# Final Plat Terra Ridge North

## Vacation & Replat of Lots 5 and 6, Terra Ridge Filing No. 1, Together with 11 Proposed Lots in Terra Ridge North

### A Portion of Section 29, Township 11 South, Range 65 West of the 6th P.M., El Paso County, Colorado

**TERRA RIDGE NORTH**  
DRAWN BY: PSM CHECKED BY: JHK DATE: 2/17/23 REV:  
FILE: TERRARIDGENORTHFINALPLAT.DWG SHEET: 1 OF 3

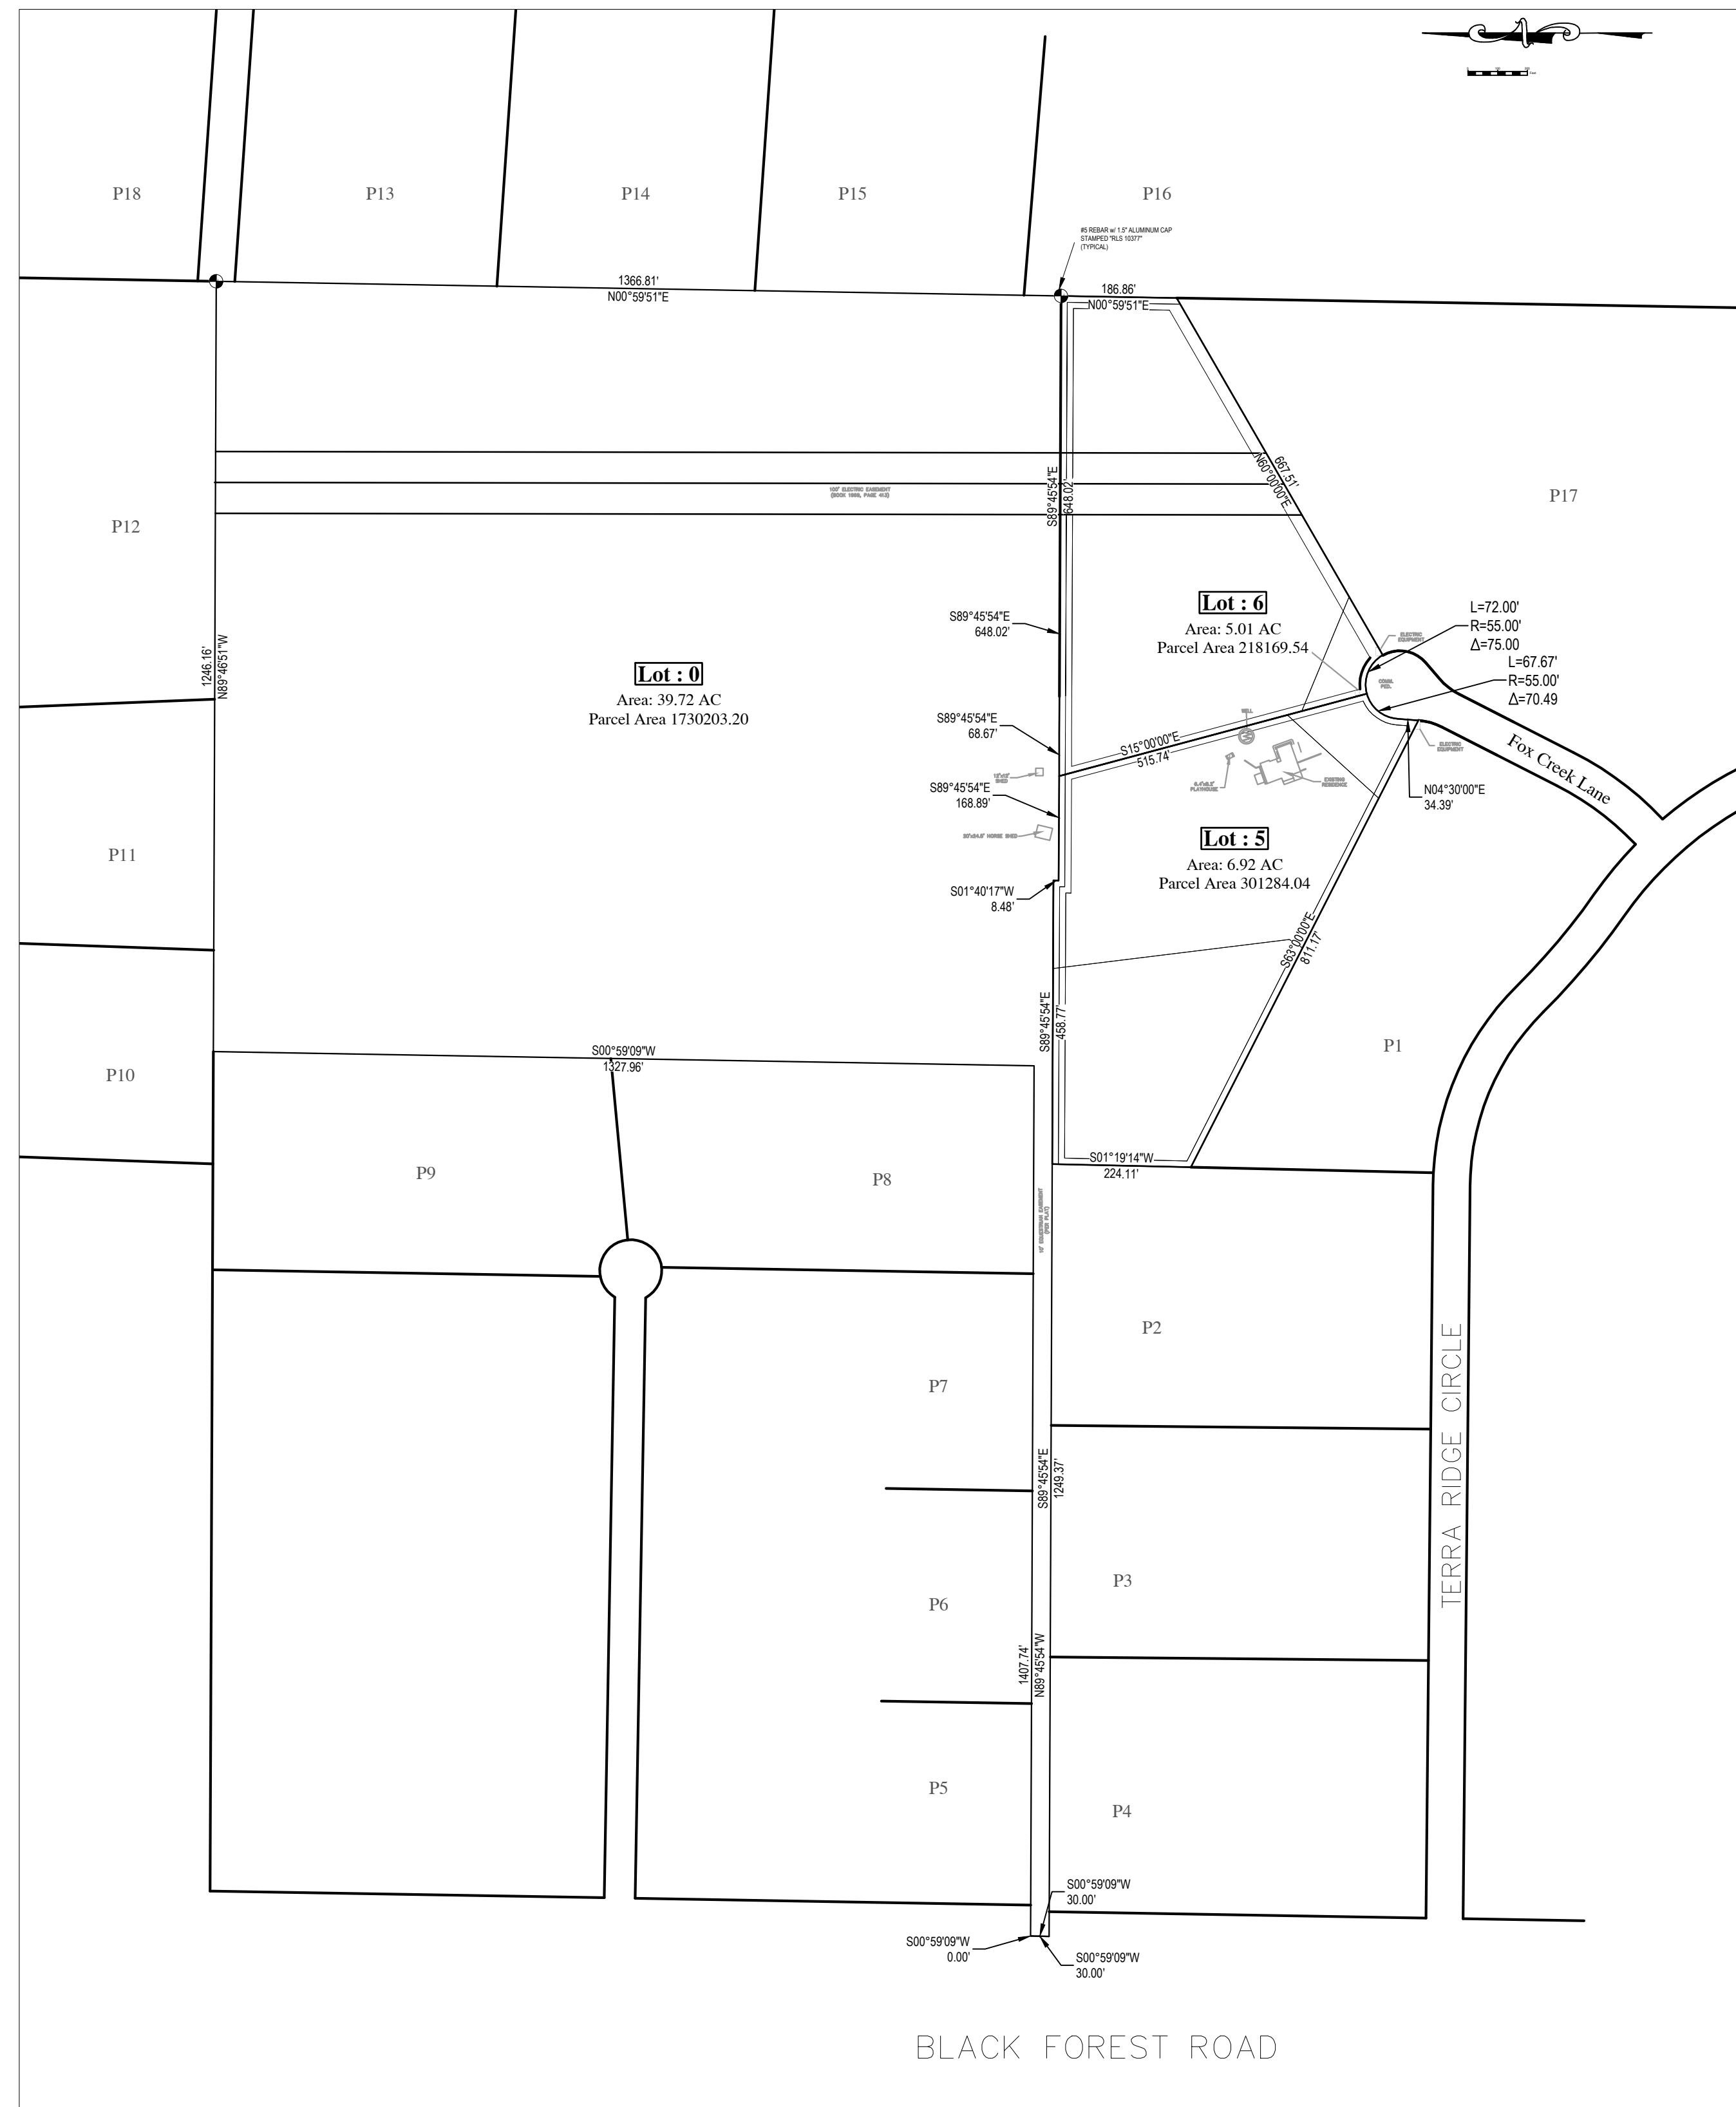
Add fire protection report and noxious weed management plan

Significant geologic constraints have been noted on the geology report. Additionally, there is a large no-build area included on the plat for the creek / potentially shallow groundwater area. Please update this note to include a description of the purpose of the no-build and a summary of the geologic constraints on the site. Use the revised Note 23 below for an example.

Add a note to identify the specific lots and tract that are subject to the shared driveway within the ingress & egress easement. Include the following statement at the end: "A maintenance agreement for said ingress and egress easement is recorded under reception no. \_\_\_\_\_. Note: the developer shall create a maintenance agreement regarding the shared driveway. The maintenance agreement should provide details about the division of financial responsibility and division of decision-making (e.g. who decides if repair/maintenance is needed and what happens if there's a disagreement?). Agreement to also define maintenance responsibility of the driveway culvert."

Add the following note: Individual lot purchasers are responsible for constructing driveways, including necessary drainage culverts from Fox Creek Lane per Land Development Code section 6.3.3.C.2 and 6.3.3.C.3.

Add a note indicating that regarding the lots that are proposed to be replatted, the original plat notes for Terra Ridge will still apply for those lots and reference the original plat number. Do the same for the covenants.

DRAWN BY: PSM CHECKED BY: JHK DATE: 2/17/23 REV:  
FILE: TERRARIDGENORTHFINALPLAT.DWG SHEET: 2 OF 3

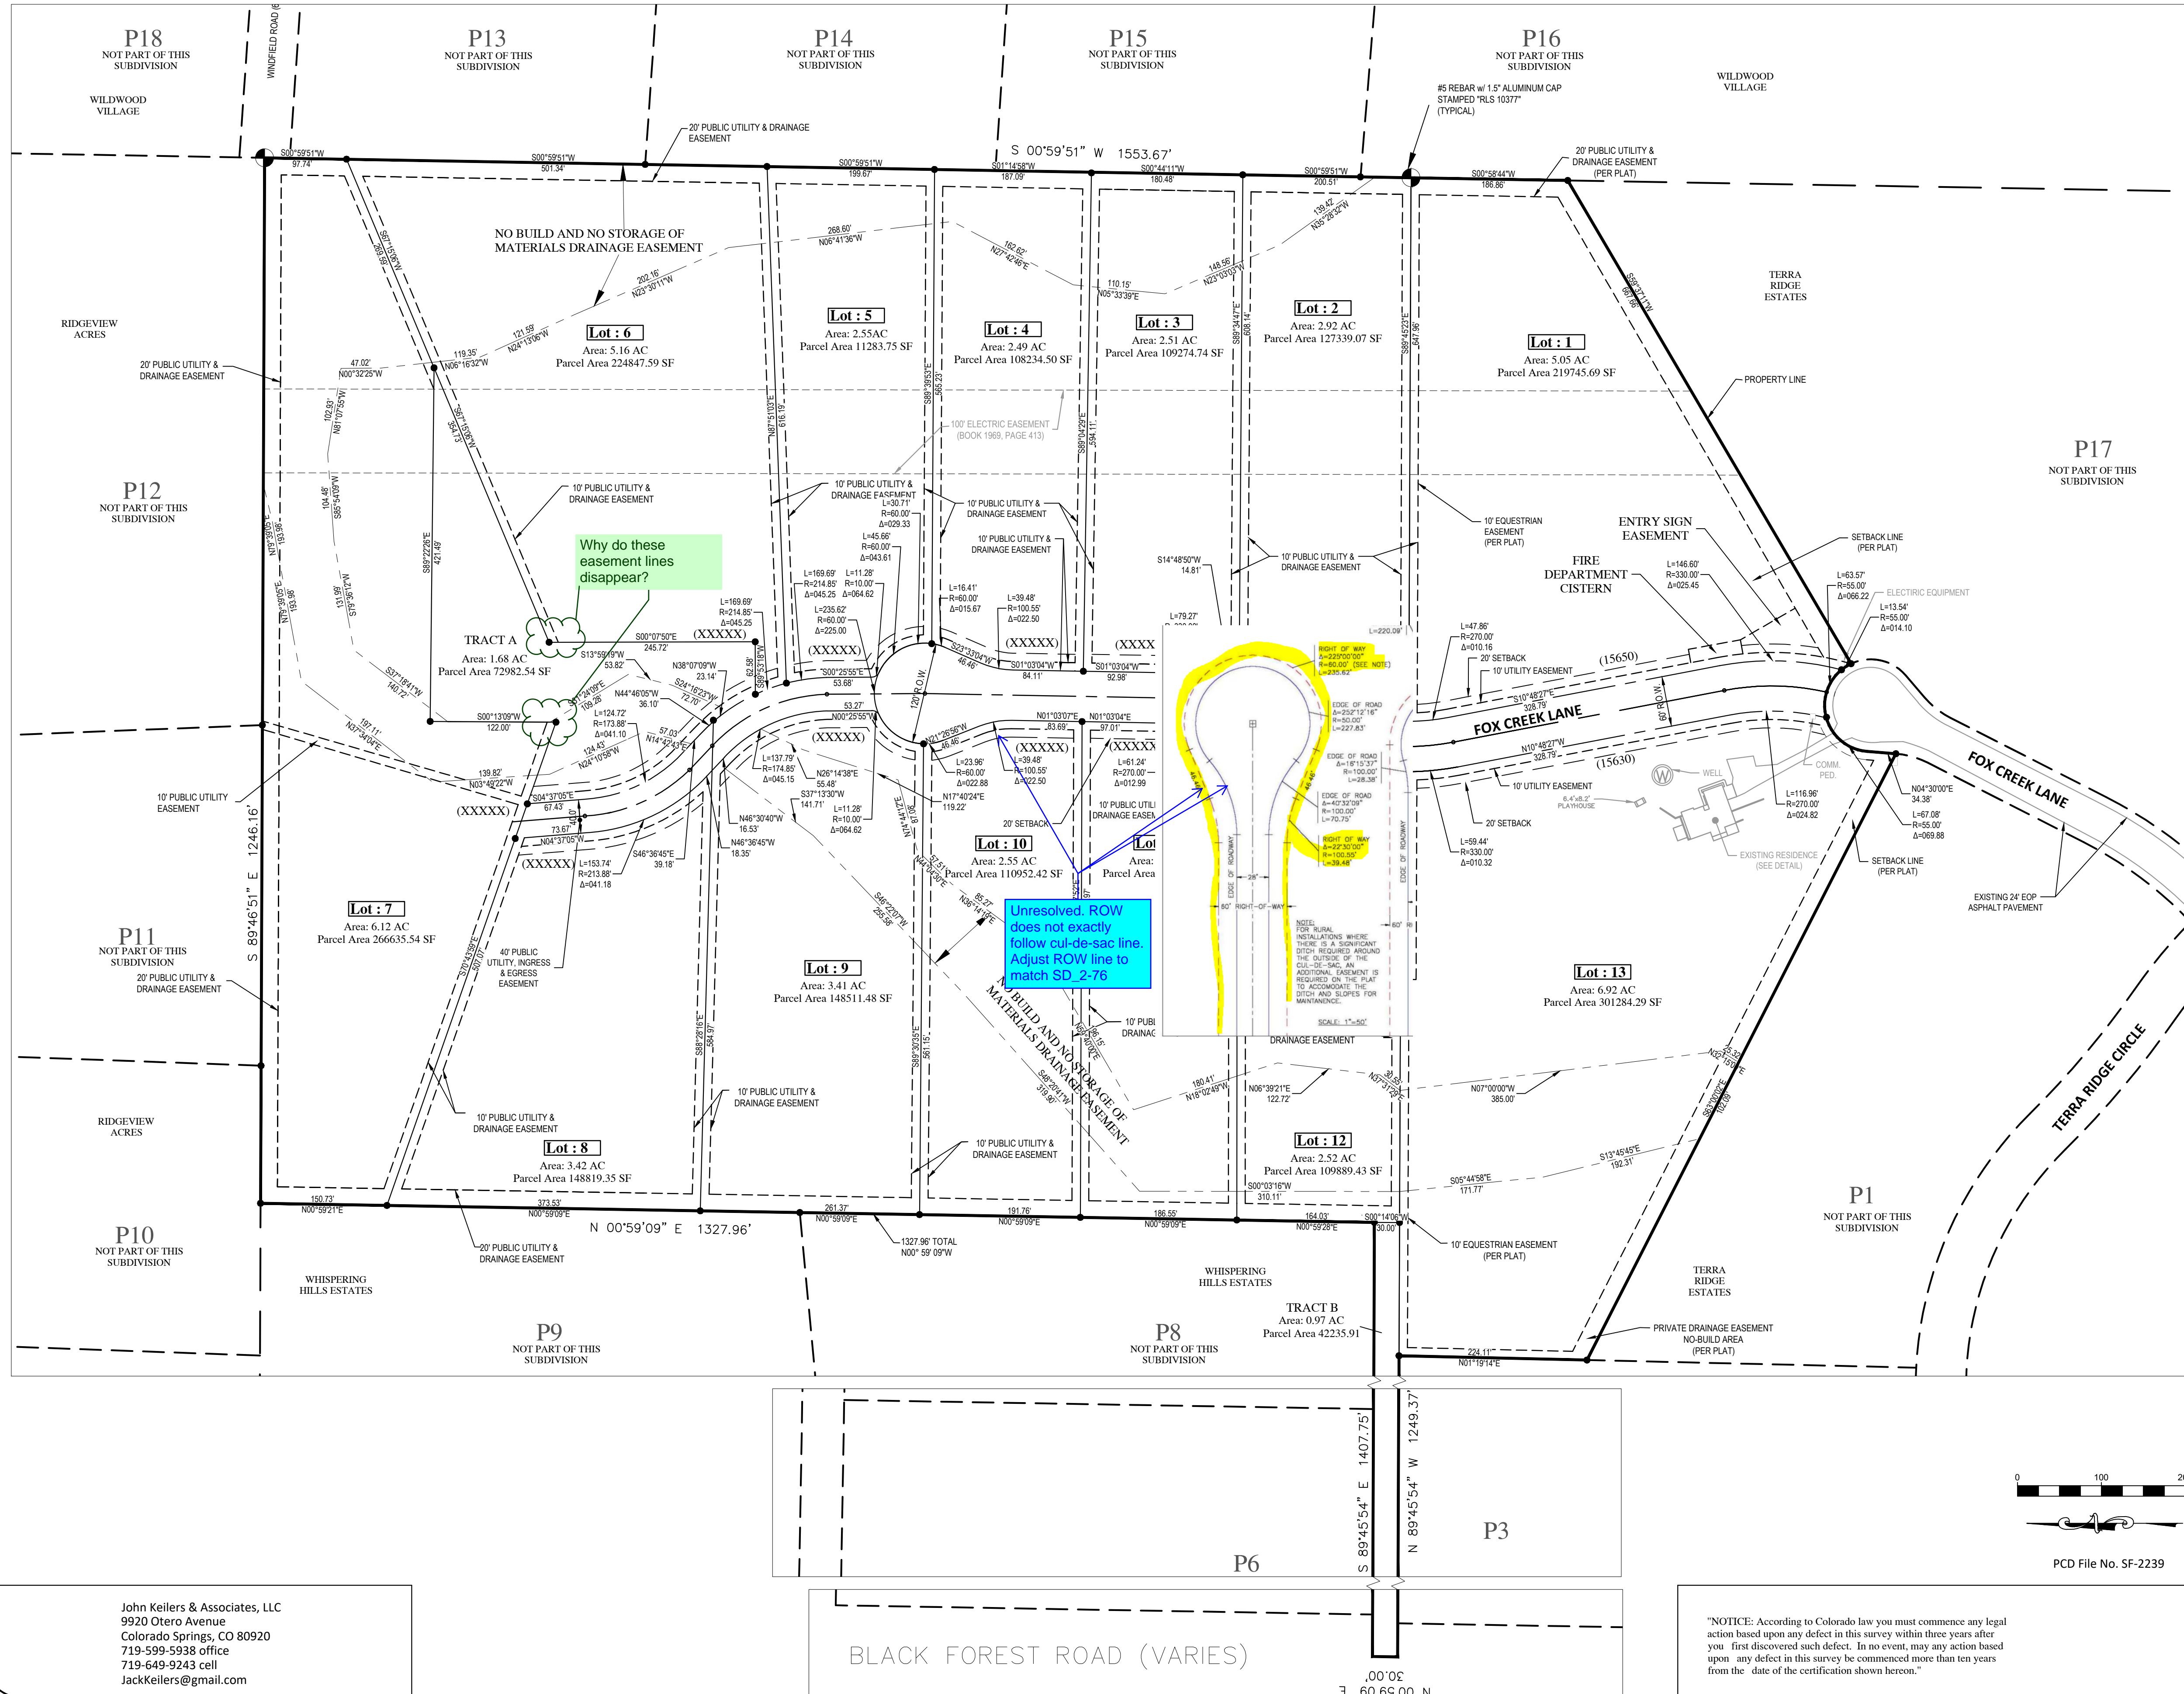
List names of all adjoining subdivisions with dotted lines of abutting lots. If the adjoining land is unplatted, it should be shown as such.

Labels reading "Not a part of this subdivision" and dashed lines delineating areas that do not constitute a part of the subdivision.

You need to include the entire property and show the surrounding properties.
